**Re: 527-529 Brighton Avenue Deck**

Ann Machado  
Zoning Administrator  
Permitting and Inspections Department  
City of Portland, Maine  
(207) 874-8709

NOT TO SCALE.

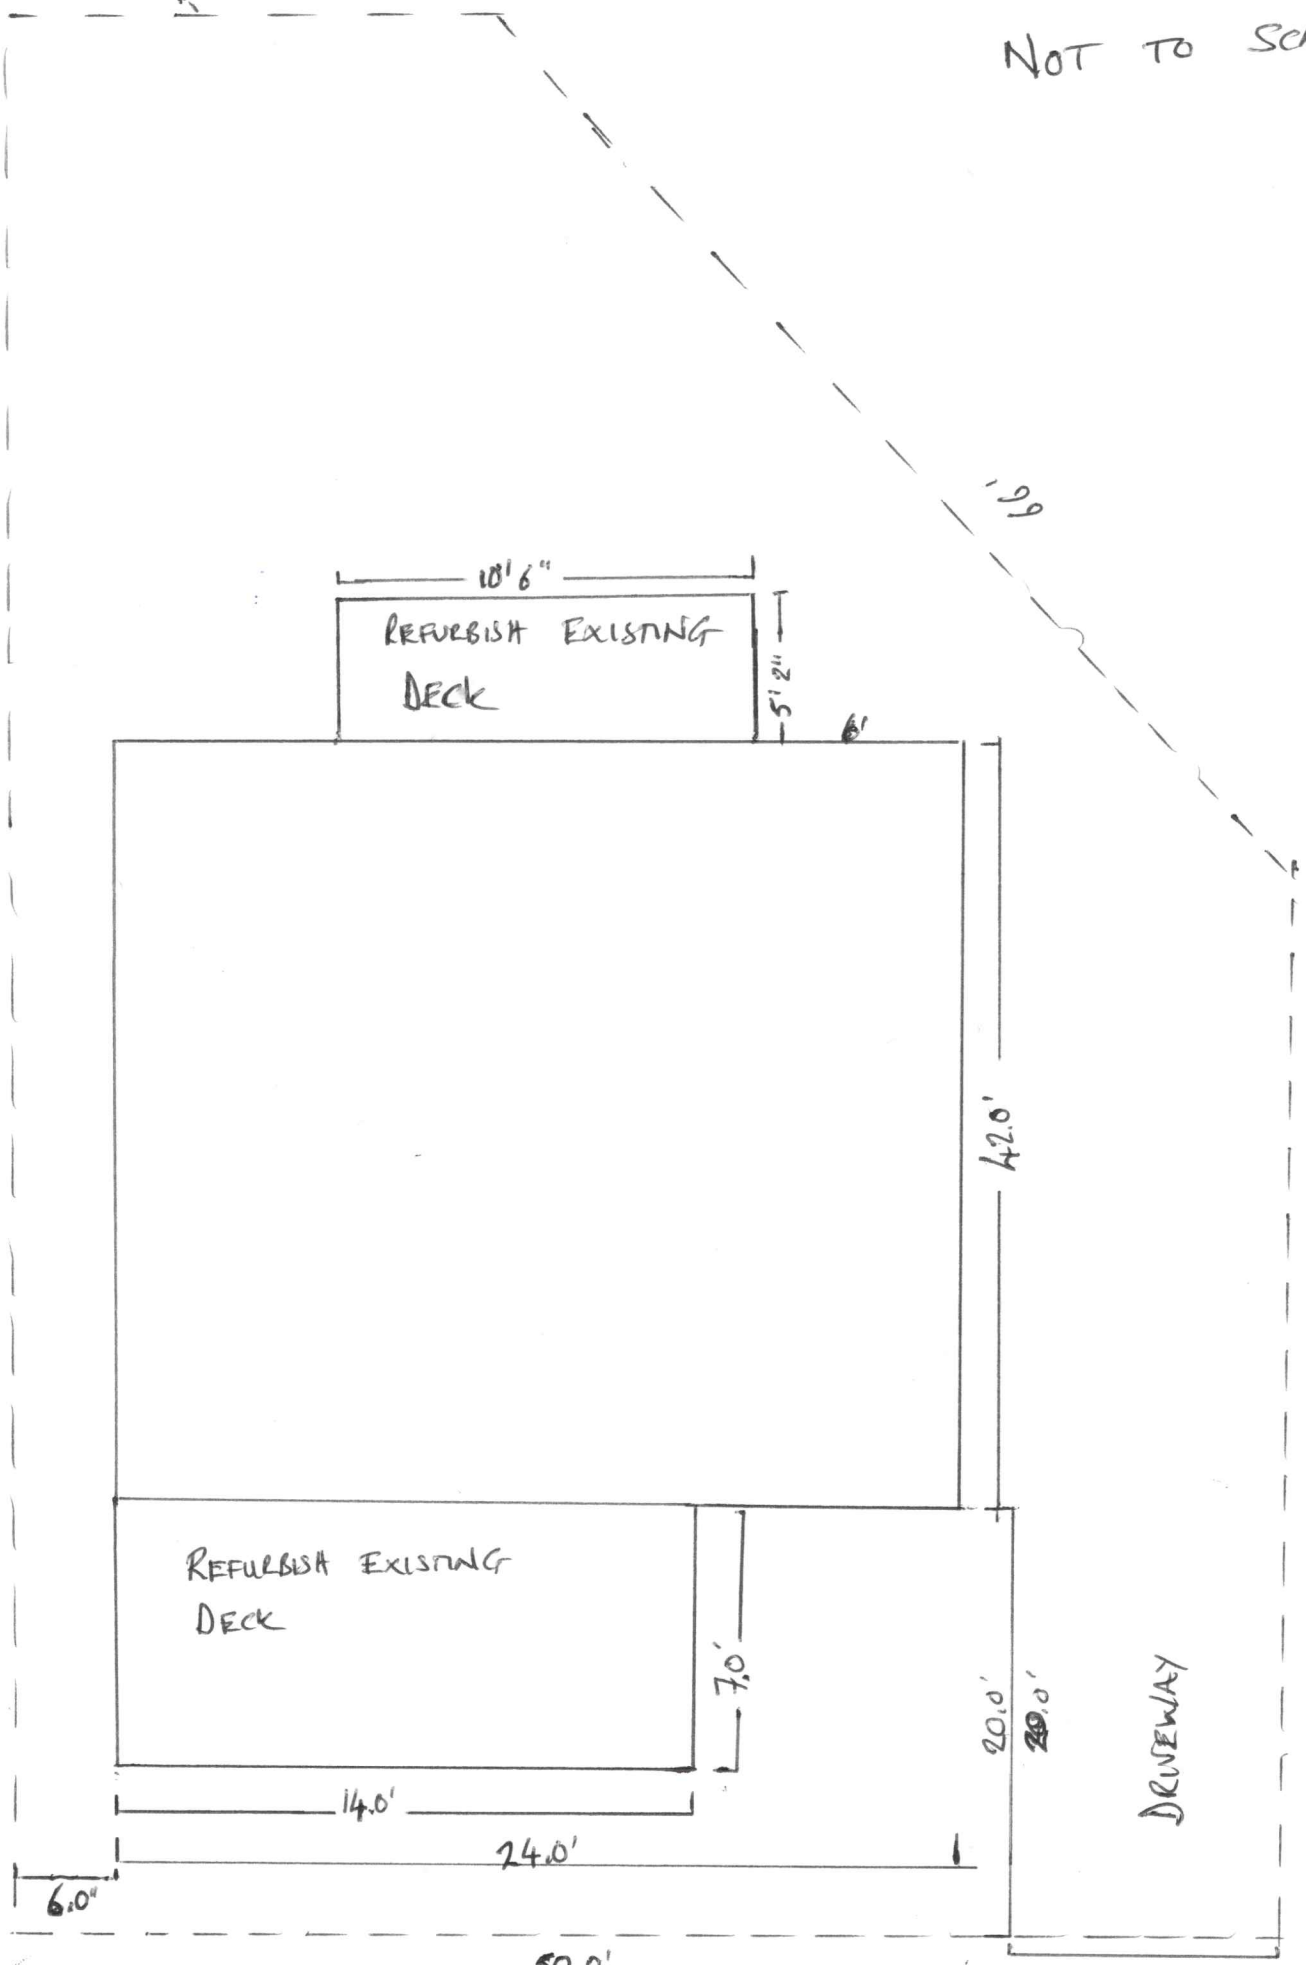
I have uploaded the revised plans that you sent. To expand the front porch two feet from 7' x 14' to 9' by 14' you need to make sure that you are meeting both the side and front setback. The side setback is 8' and your plot plan is showing 6' so you would not meet that. For the front yard, if the setback is less than 20' you need to take the average of your neighbors existing front setback. You would need to measure from the front property line to the closest part of their structure whether it is the stairs, the porch or the front of the house. You would need to show these measurements on the plot plan. Since you don't meet the side setback, you won't be able to do it.
